From: M NORRELL 
Sent: 12 December 2014 15:20
To: Simon Davis
Subject: Re: Application AL/75/14/OUT Woodgate Farm

I am the case officer for your application. Having now had chance to properly analyse the application, I am of the view that 3 houses is too much. My reasoning is that the current scheme fails to comply with Councils space standards policies as set out in the emerging Local Plan (Policies D DM2 & D DM3). You can view these in this part of the emerging Local Plan:

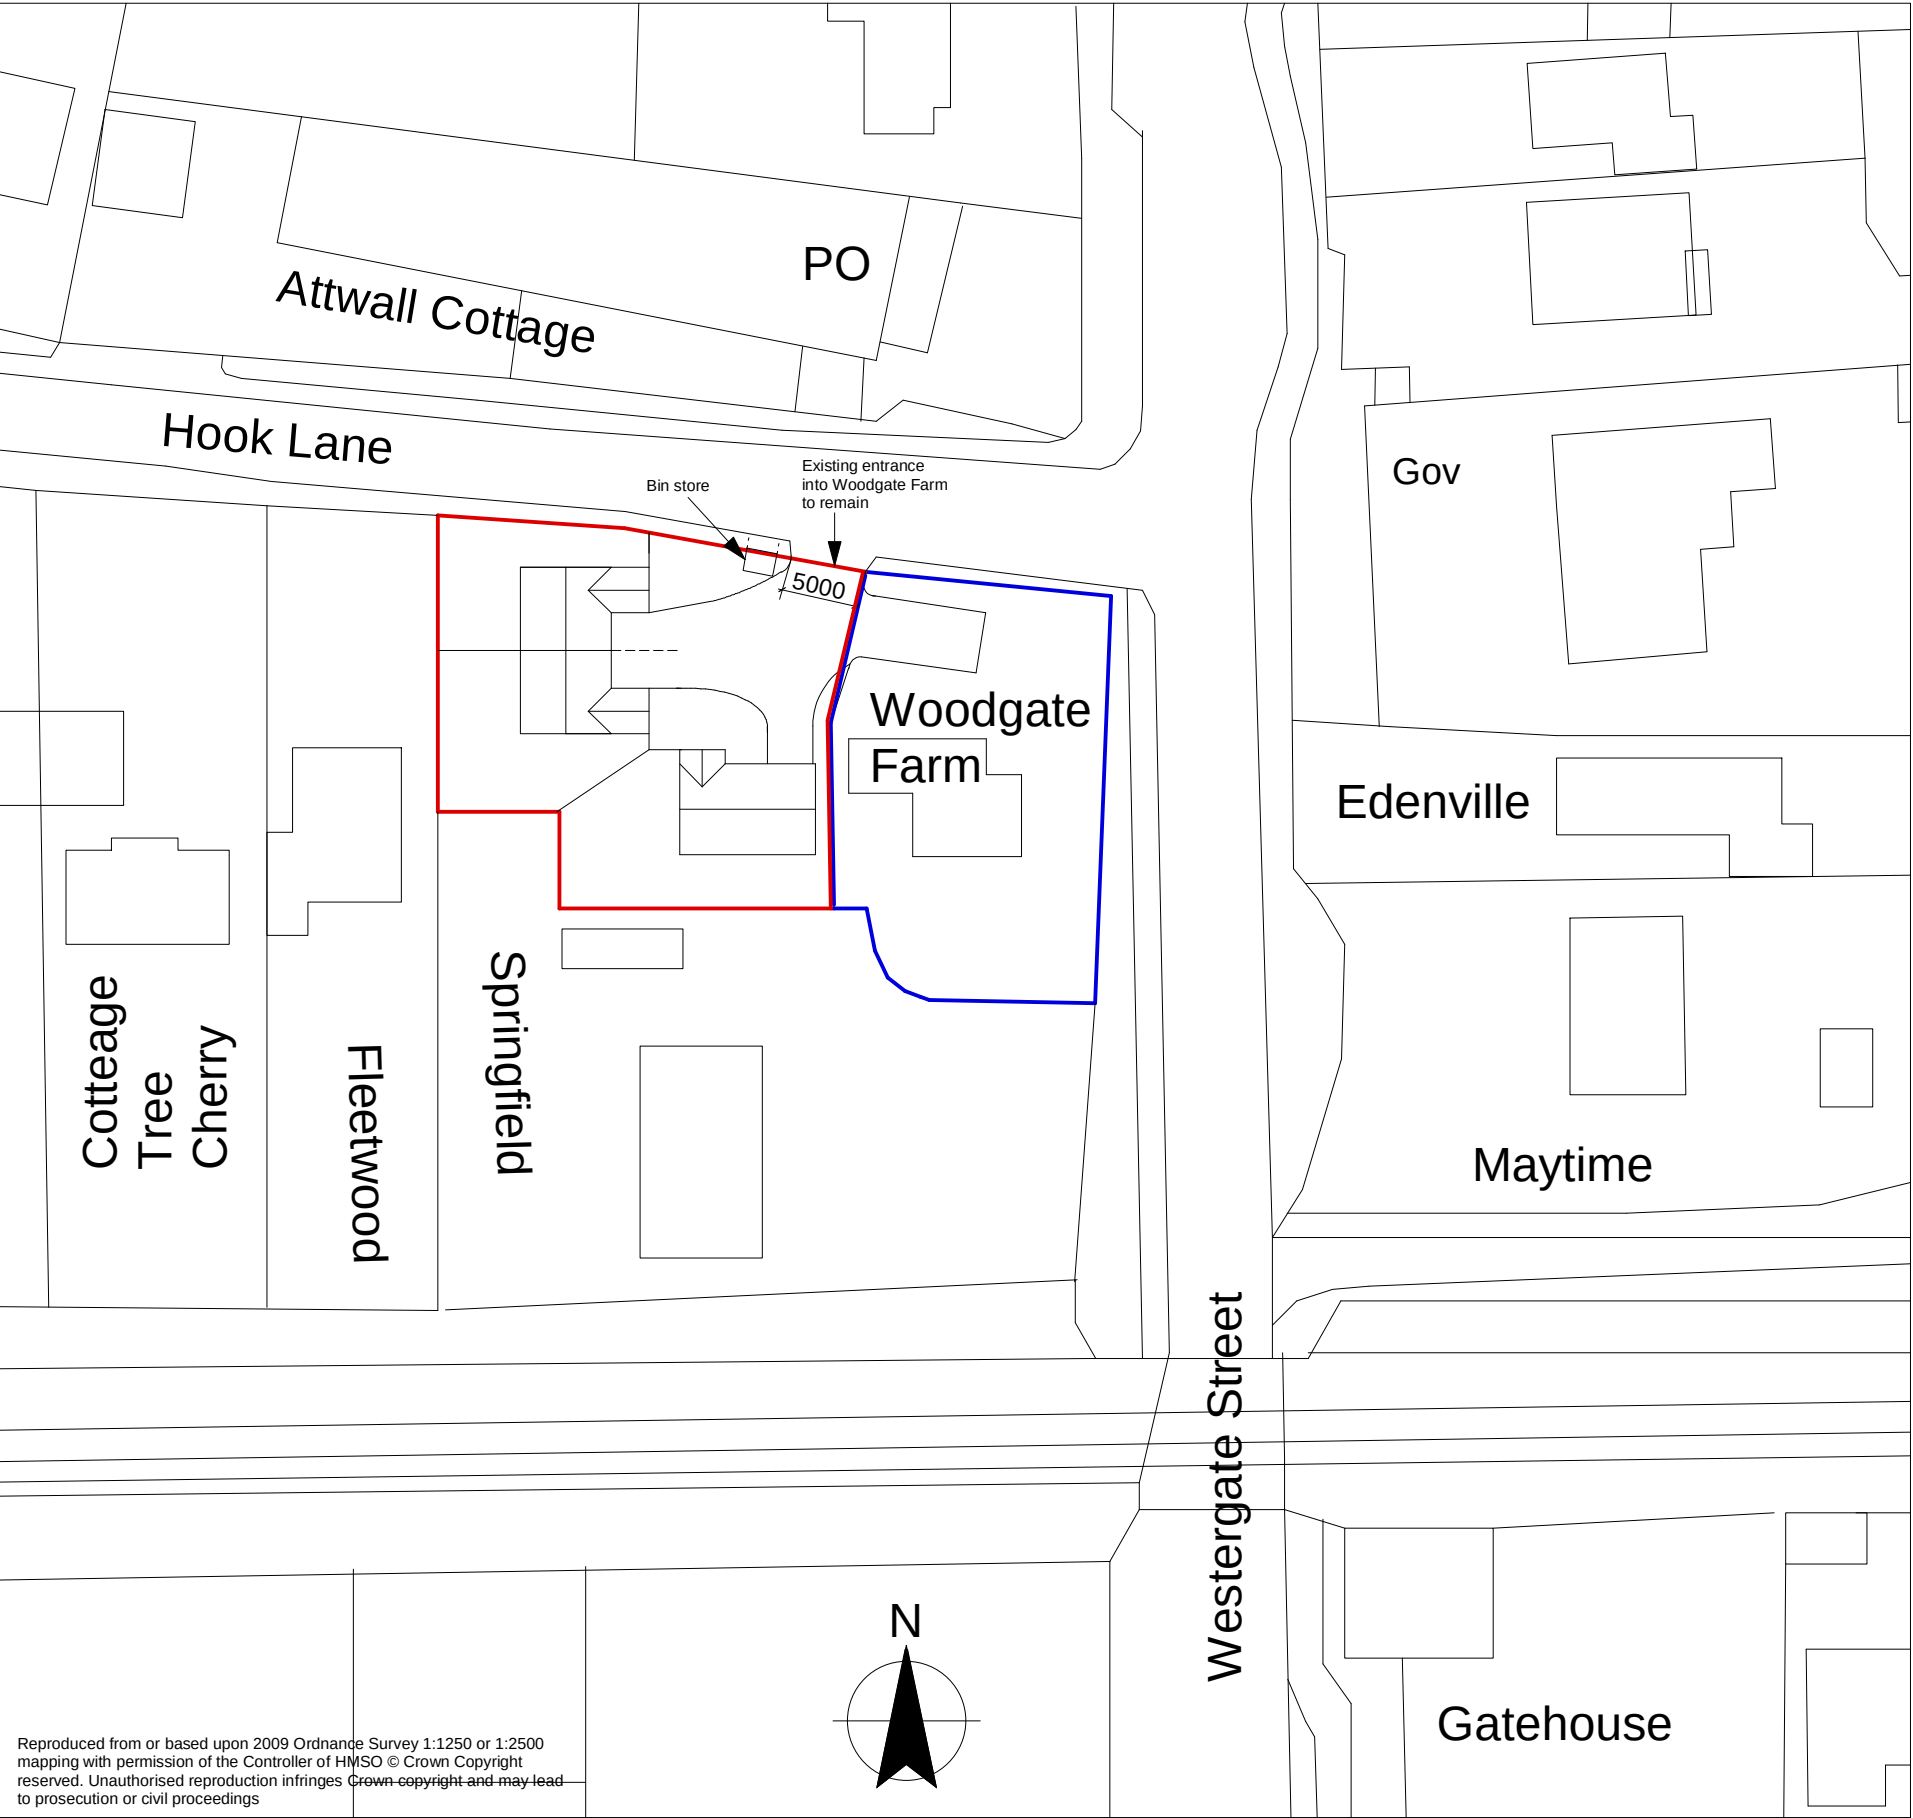
I consider that the dwellings will not comply with either the internal space standards or the external space standards and I am also concerned as to how much garden Woodgate Farm is left with. I appreciate that the site layout is only indicative at this stage but I don't believe that 3 houses can be accommodated whilst adhering to our policies. If you can agree to change the description to 2 then I will be able to recommend approval, otherwise it will have to be a refusal. Please note that I won't need a new indicative layout, just your clients agreement to the amended description. I also won't need to re-consult neighbours/consultees. However, regardless of the recommendation, I won't be able to determine this by the 17th December but I will send an Extension of Time request to you separately to cover that aspect.

Please find the signed extension request form and I can confirm that my client and applicant Mr & Mrs Horsman are in agreement to change the description form 3 to 2 units and amend the application description.

Thank you for your email and I will confirm back to you tomorrow after I have had chance to speak with my client. I do not see there being any problem with my client to reduce the proposal to 2 units in line with your email.
